CITY OF ALBUQUERQUE
PLANNING DEPARTMENT
DEVELOPMENT REVIEW BOARD

10. Project # 1002778
05DRB-01383 Major-Amnd Prelim Plat Approval

**CITY OF ALBUQUERQUE
PLANNING DEPARTMENT
September 7, 2005
DRB Comments**

RE: Western Ridge, Units 1 &2/app

AMENDED PRELIMINARY PLAT  
**UNIT 2**  
**WESTERN RIDGE SUBDIVISION**  
 (REPLAT OF TRACT 2 & 9  
 AT VENTANA RANCH WEST)  
 ALBUQUERQUE, NEW MEXICO  
 SEPTEMBER, 2004

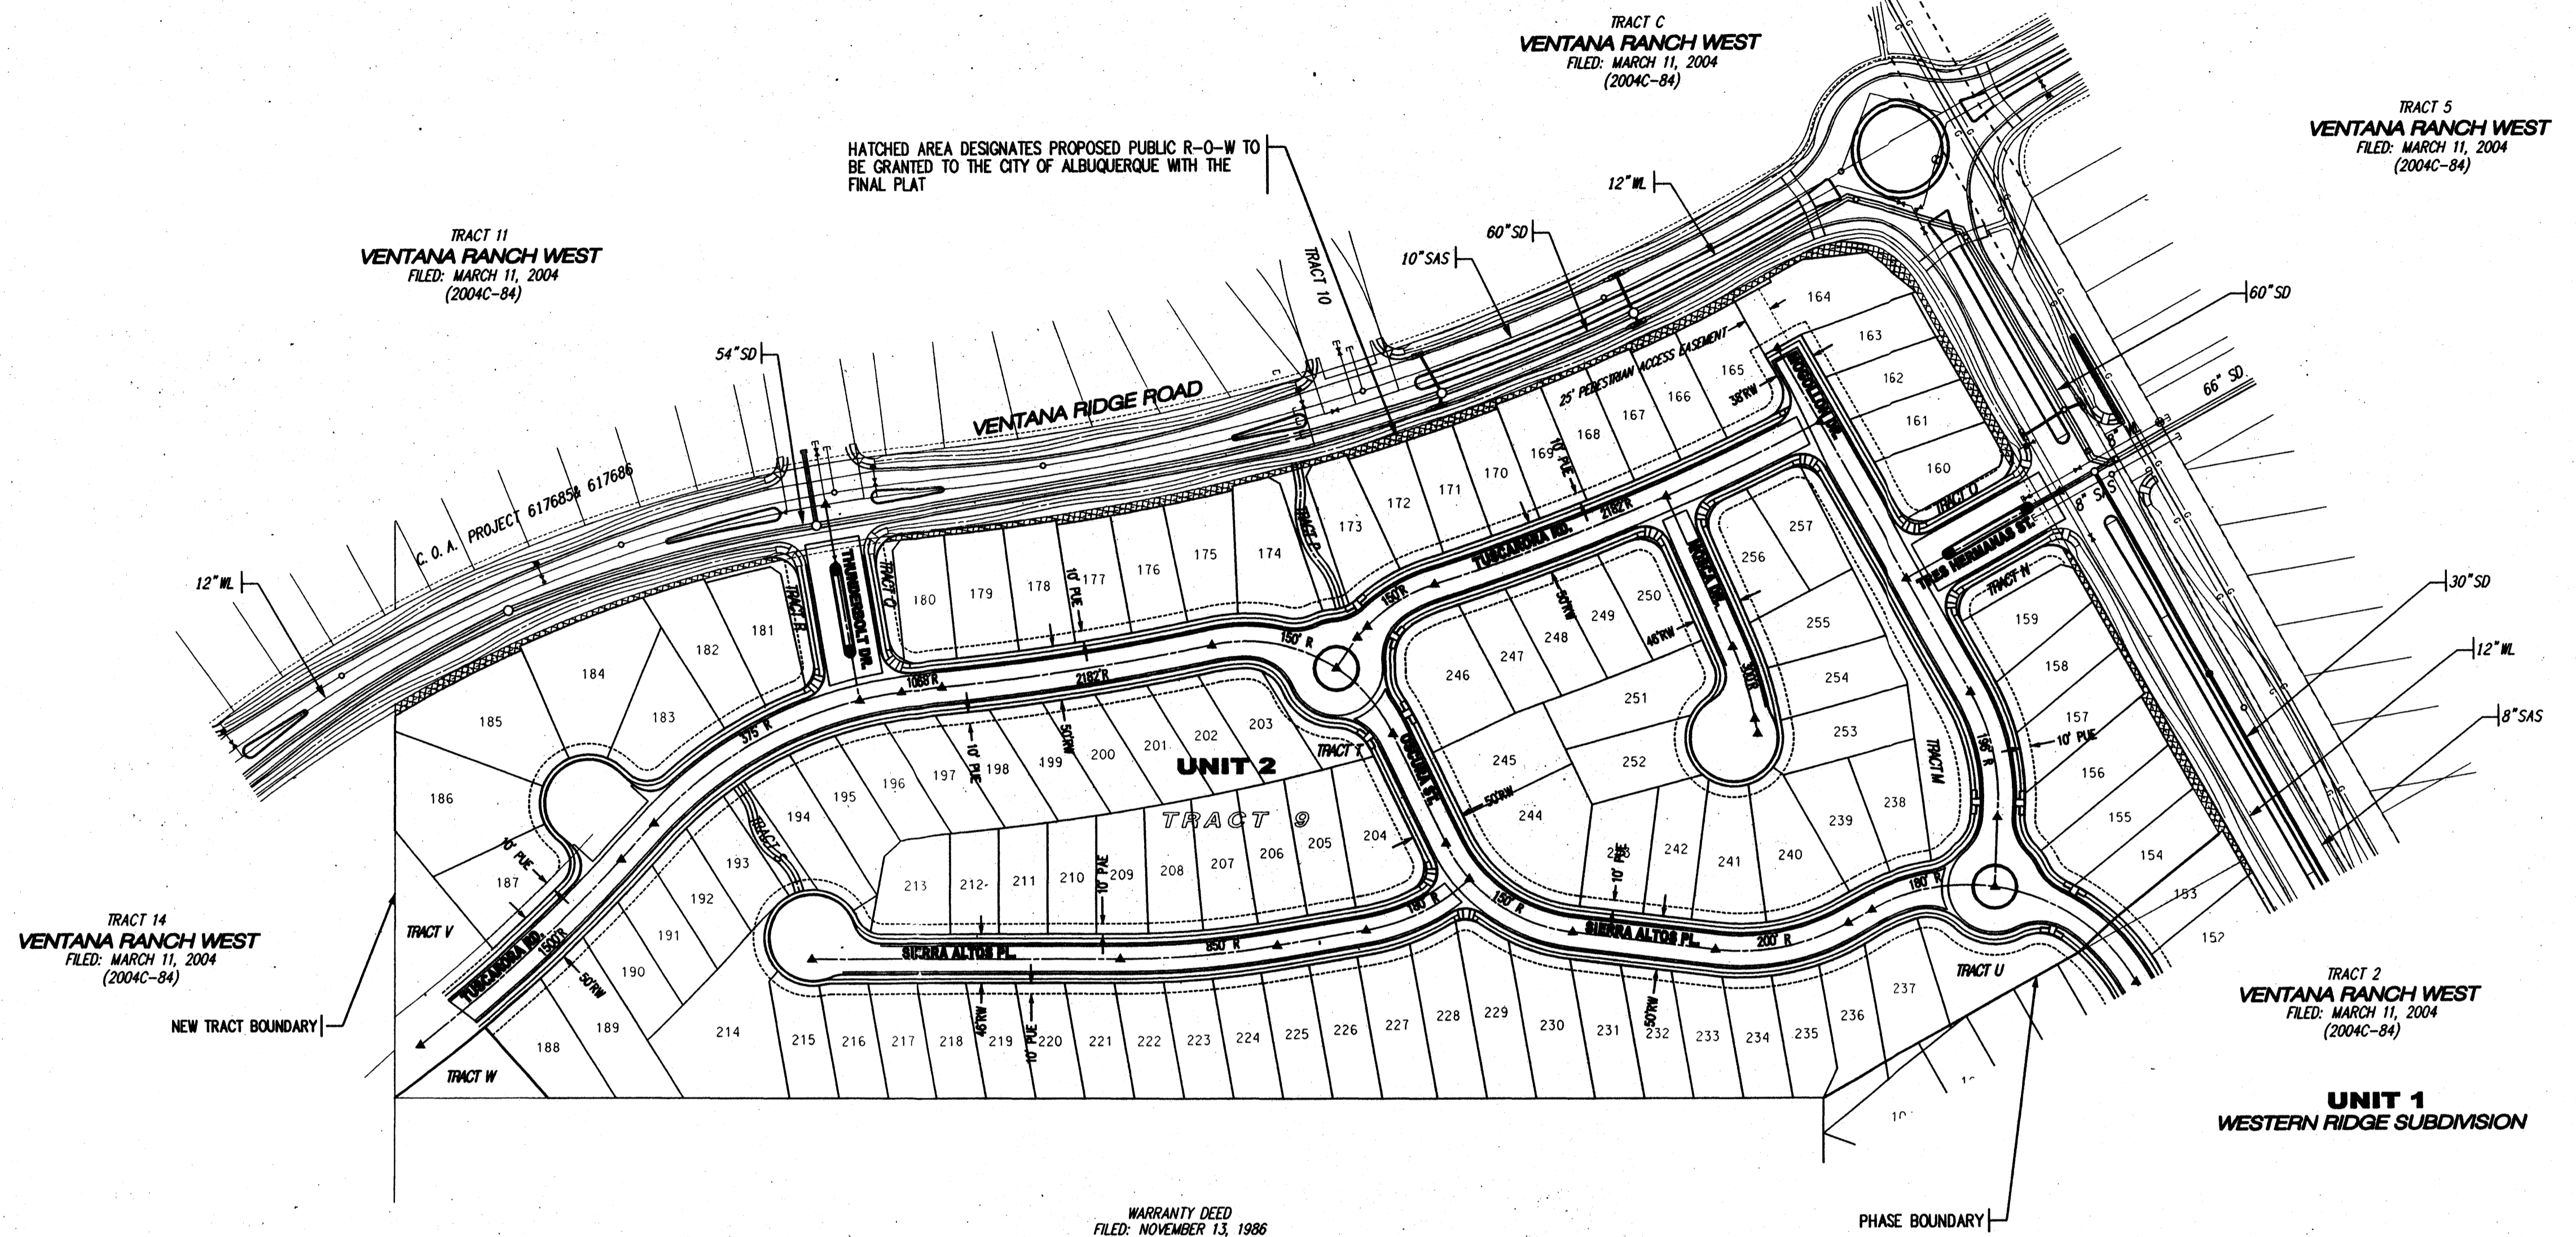
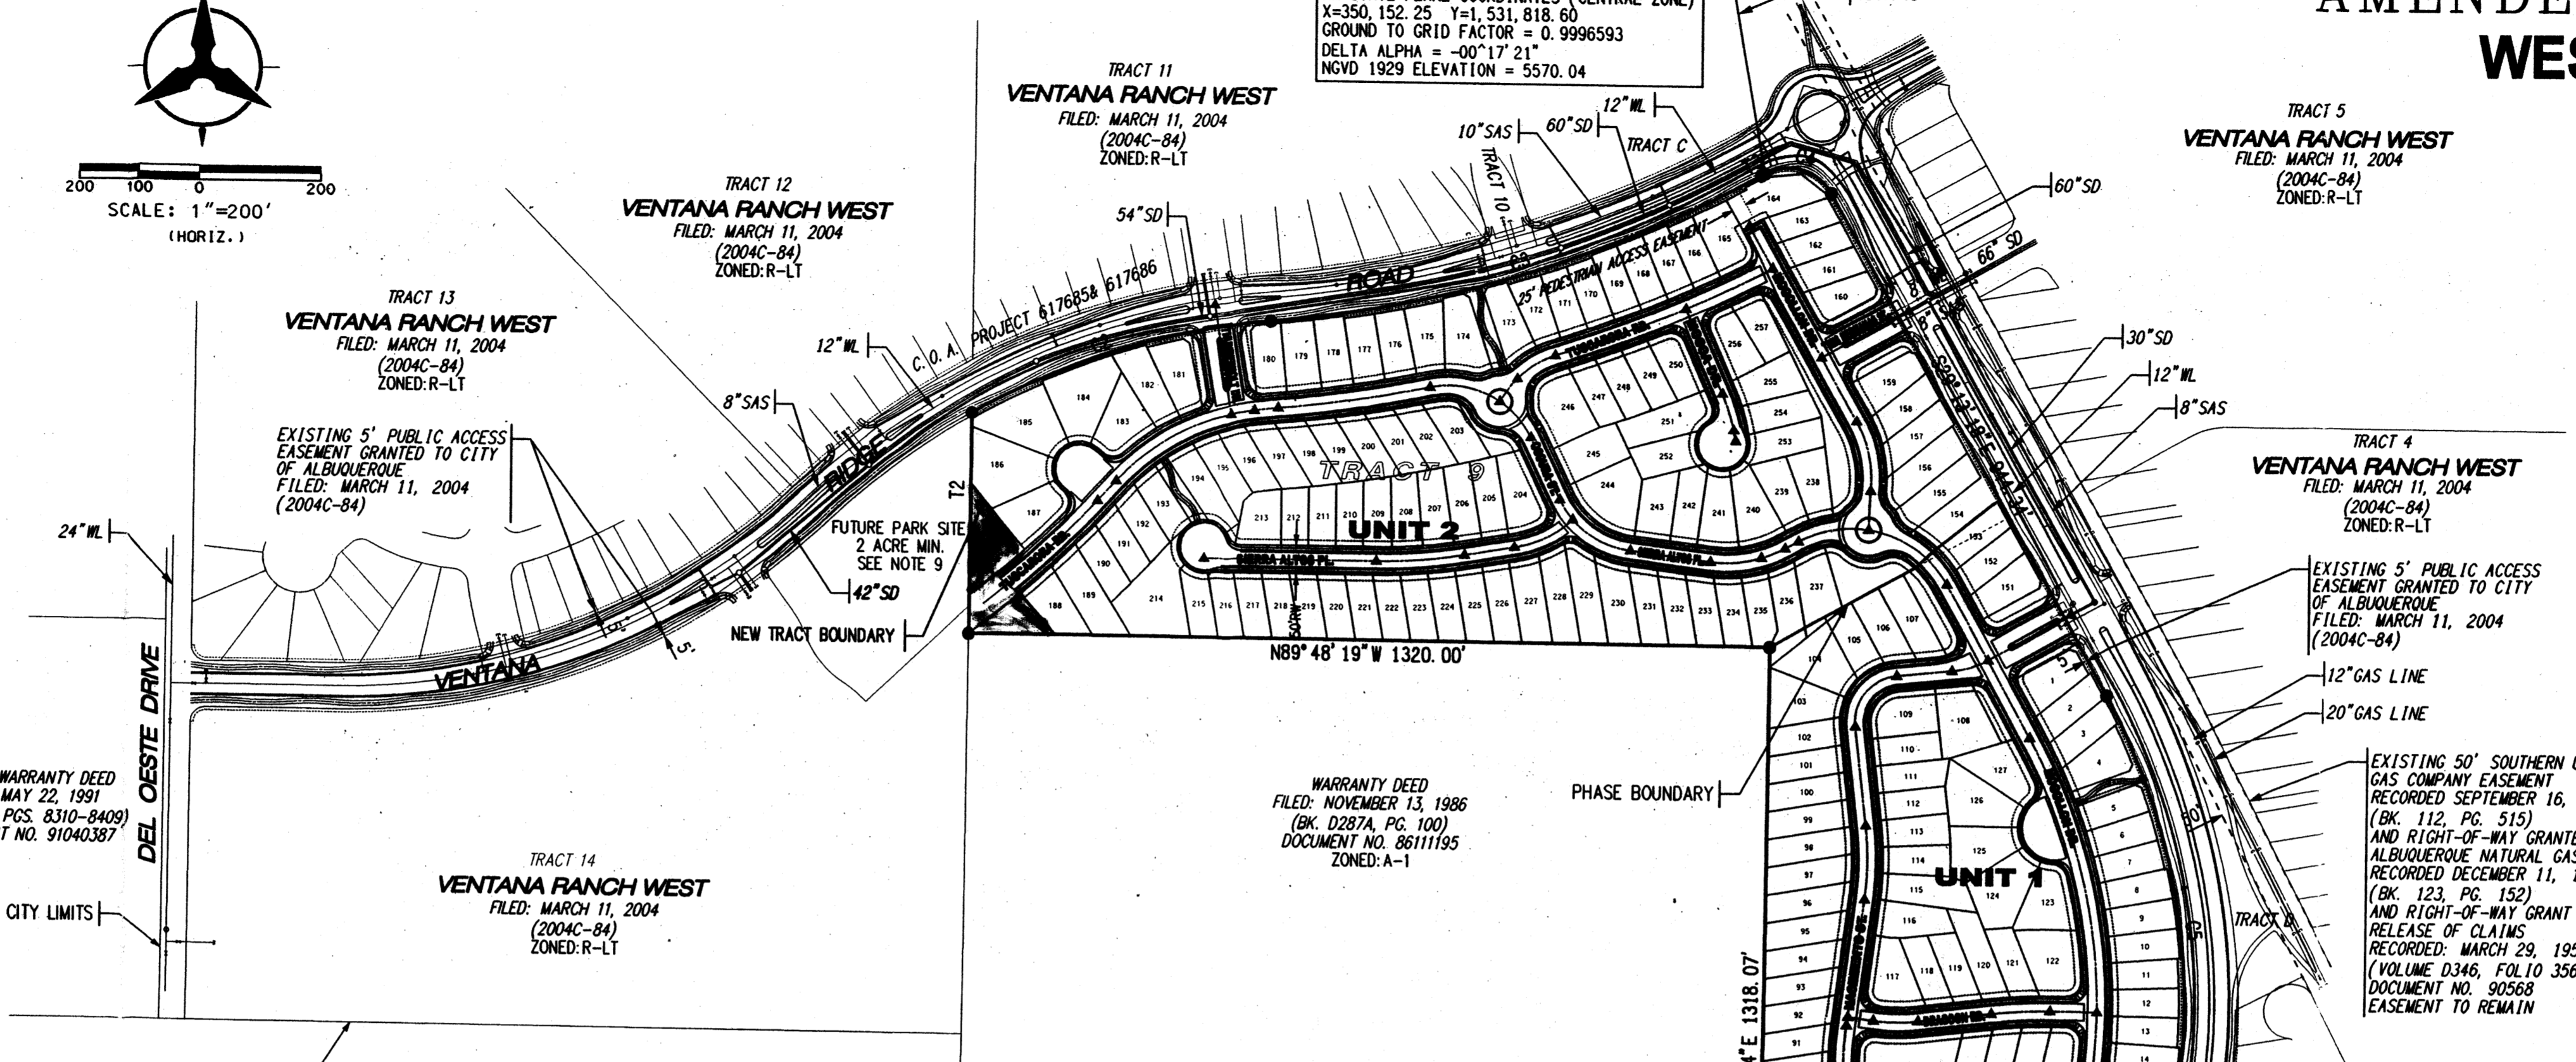
There are two unidentified pieces of property on the NW corner of the plat. They should either be identified or incorporated into adjoining lots.
